**From:** Andrew Lissenden <Andrew.Lissenden@shoalhaven.nsw.gov.au>  
**Sent:** Monday, 25 July 2016 2:06 PM  
**To:** Deana Burn  
**Subject:** Shoalhaven Starches Modification 9 - Comments from Shoalhaven City Council  
**Attachments:** SW DA Notice - 3A07-1008 - N3 (MOD 9).DOCX

**From:** Andrew Lissenden  
**Sent:** Monday, 25 July 2016 1:58 PM  
**To:** 'Deana.Burn@planning.nsw.gov.au' <Deana.Burn@planning.nsw.gov.au>  
**Cc:** Chris Ritchie <Chris.Ritchie@planning.nsw.gov.au>; Cathy Bern <Cathy.Bern@shoalhaven.nsw.gov.au>  
**Subject:** HPRM: Shoalhaven Starches Modification 9 - Comments from Shoalhaven City Council

Further to your emails requesting comments on the above modification, including the additional amendments made by the proponent, please find below comments from Shoalhaven City Council in relation to Shoalhaven Starches Modification No.9. The main issues for Council relate to traffic/road impacts, sewer/water, flooding and visual impacts. In summary, Council has no objection in principle subject to the following conditions/requirements being included in any updated approval issued. To assist comments have been provided separately below on each specific issue with

Figure 8: Recommended Sound Barrier Screening.

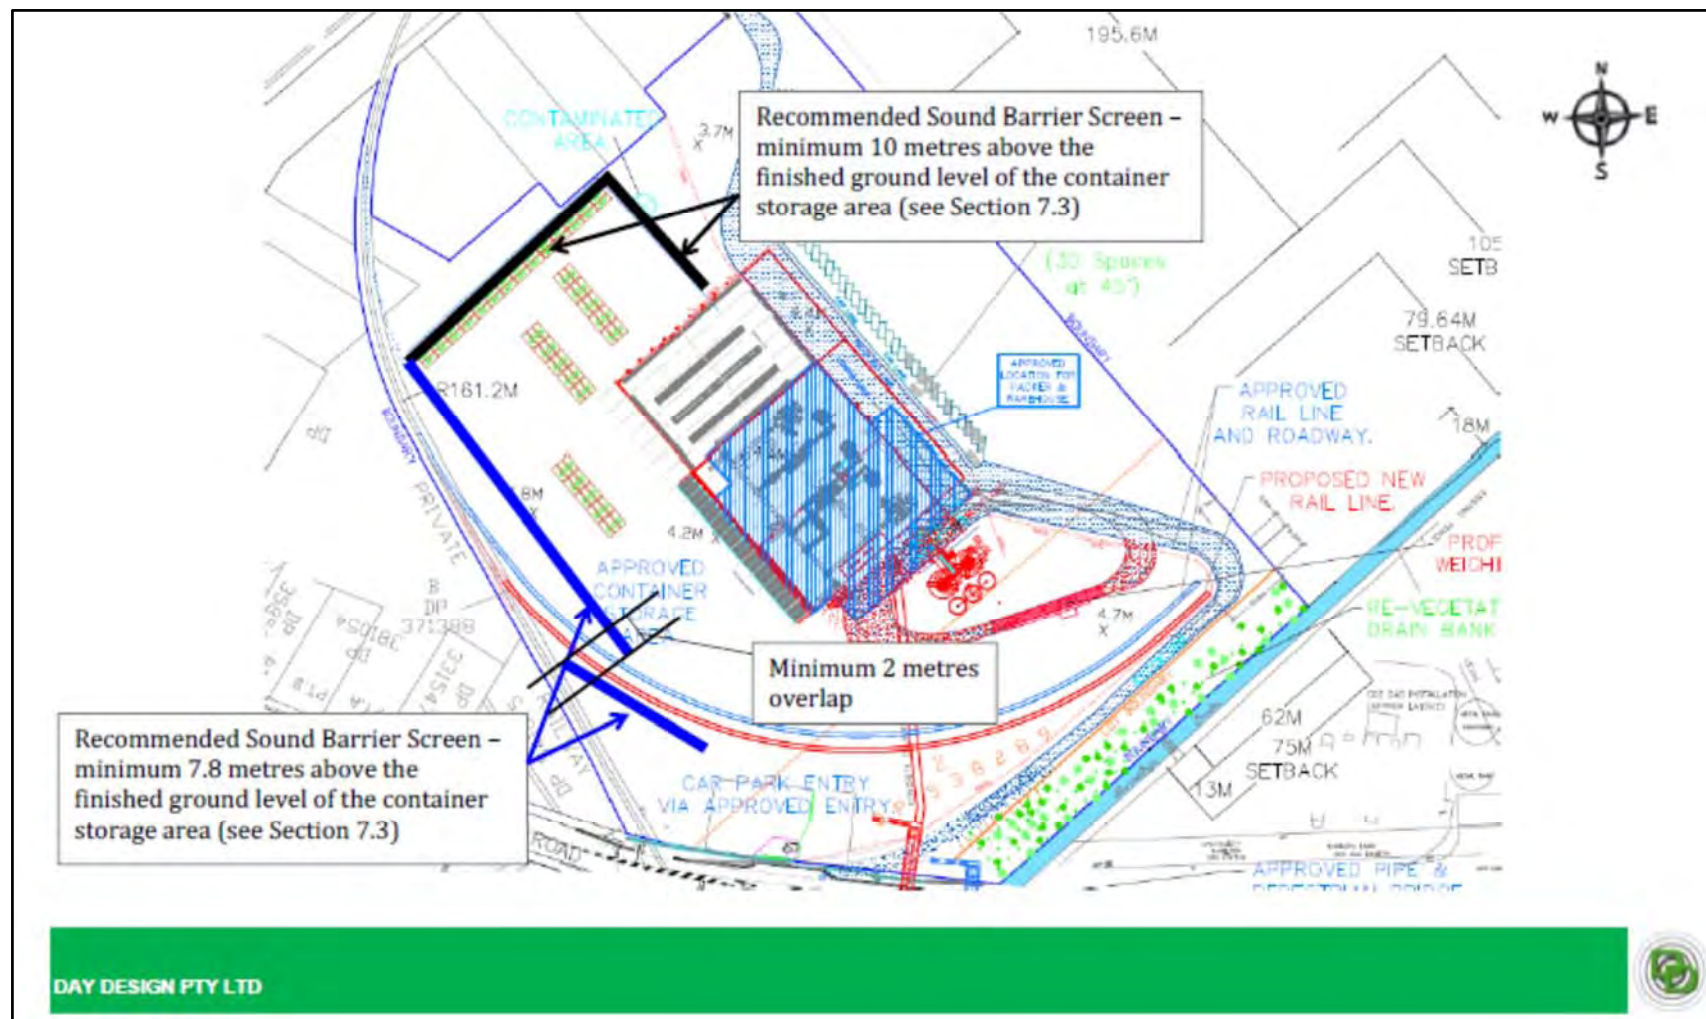
- All car parking to be provided is to be in accordance with this application must be designed and constructed in accordance with AS2890 requirements;
- Pedestrian access to the development site from the car park areas must be provided in accordance with A.S.1428. Plans demonstrating compliance with this must be approved by the Principal Certifying Authority prior to issue of a Construction Certificate; and
- All works within the road reserve/within public land will require a Section 138 Application under the Roads Act to be lodged with Council.

Figure 35: Photomontage of proposed Modified Packing Plant as seen from Bolong Road.

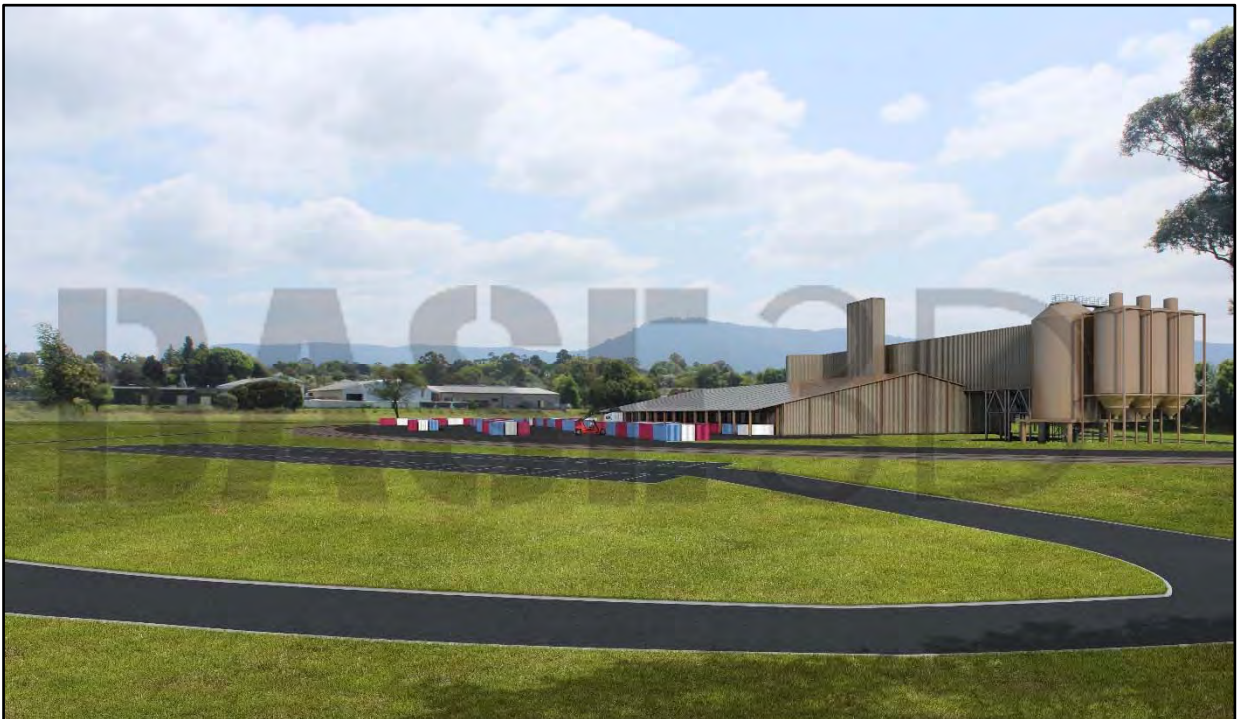
Given the Packing Plants increased size, the increased amount of fill, an increase in associated storage area and the its location in an area that, when viewed from Bolong Road, has an appearance of having a rural character, regard should be had for exterior materials used and associated visual impacts from the development when viewed from Bolong Road. While it is acknowledged that a Landscape and Vegetation Management Plan that supported the original Environmental Assessment made provision for landscape screening along the northern side of Bolong Road, limited details on this screening proposed (i.e. specific plants, planting densities, pot sizes, etc) could be found. It is therefore recommended that the following conditions be included.

8. Exterior materials (excluding windows and other glazing) are to be non-reflective and of a texture and colour which blend with the existing surroundings. Zincalume materials shall not be used unless it can be demonstrated that it will not have an adverse impact and/or create a glare nuisance.

9. A landscape plan that details landscape treatment within Lot 16 DP 1121337 to the south of the proposed new rail line for its length should be prepared by a registered (or eligible for registration) landscape architect. The landscape plan should detail plant species to be used noting that these should be species that are endemic to the area and should grow to a sufficient size so as to provide a screen to the Packing Plant development and associated infrastructure when viewed from Bolong Road. The plantings should be at a minimum of 5m centres and be a minimum 45 litre pot size. The plan should be provided to Secretary and Council for comment prior to issue of a Construction Certificate for the Packing Plant.

Figure 41: Extract from WMAwater Flood Assessment (Image 3).

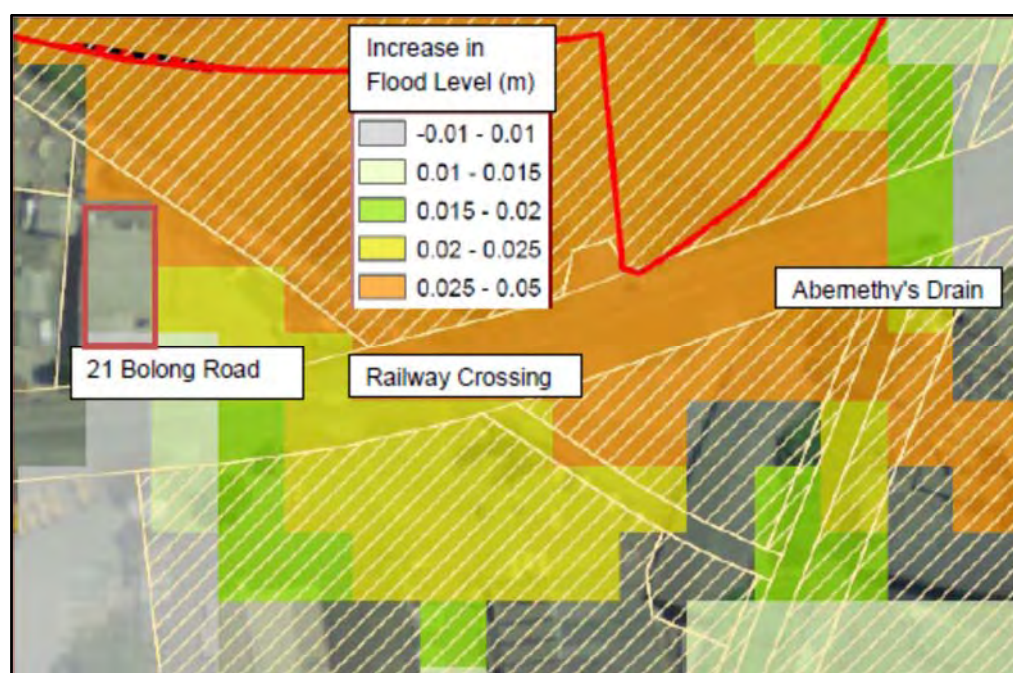
The proposed modifications to the Packing Plant and DDG Pellet Plant fall under the land use category in the flood chapter of the Shoalhaven Development Control Plan 2014 (SDCP 2014) of 'Commercial/Industrial/Agricultural Buildings/Retail'. The area is where the Packing Plant is proposed is categorised as 'high hazard flood storage' while the area where the DDG Pellet Plant is proposed is categorised 'high hazard floodway'. The development needs to satisfy the requirements shown in the planning matrix in Schedule 6, Chapter G9, of the SDCP 2014. In the absence of acceptable solutions being met, the Flood Assessment Report provided by the proponent needs to demonstrate how the objectives and performance criteria are being met. In summary, Council is not satisfied that the proponent has submitted sufficient information to address the performance criteria. The floor level proposed for the Packing Plant extension is 4.40m AHD which is below the projected 2050 flood planning level of 6.2m AHD. The floor level of the DDG Pellet Plant is 4.70m AHD which is below the projected 2050 flood planning level of 6.4m AHD. For the both the Packing Plant component and DDG Pellet Plant component of the modification the proponents submitted flood assessment has not adequately addressed that the proposed floor levels and how fill will not place the proposed structure or surrounding areas at increased risk of flooding.

6. Prior to the commencement of any filling works associated with the Packing Plant or issue of a Construction Certificate for the Packing Plant as approved under Mod 9, whichever comes first, the proponent must demonstrate through the preparation of a flood assessment report that looks at the full range of flood events, that the proposed floor levels and fill do not place the Packing Plant as approved under Mod 9 or surrounding areas at increased risk of flooding. This is to be prepared by a suitably qualified consultant and submitted to

Council for approval prior to commencing the identified works (i.e. fill and buildings). This is to be prepared as per guidance in Chapter G9 of the Shoalhaven Development Control Plan 2014.

7. Prior to issue of a Construction Certificate for the DDG Pellet Plant as approved under Mod 9 the proponent needs to demonstrate through the preparation of a flood assessment report that looks at the full range of flood events, that the DDG Pellet Plant as approved under Mod 9 and associated floor levels do not place the proposed structure or surrounding areas at increased risk of flooding. This is to be prepared by a suitably qualified consultant and submitted to Council for approval prior to commencing the identified works. This is to be prepared as per guidance in Chapter G9 of the Shoalhaven Development Control Plan 2014.
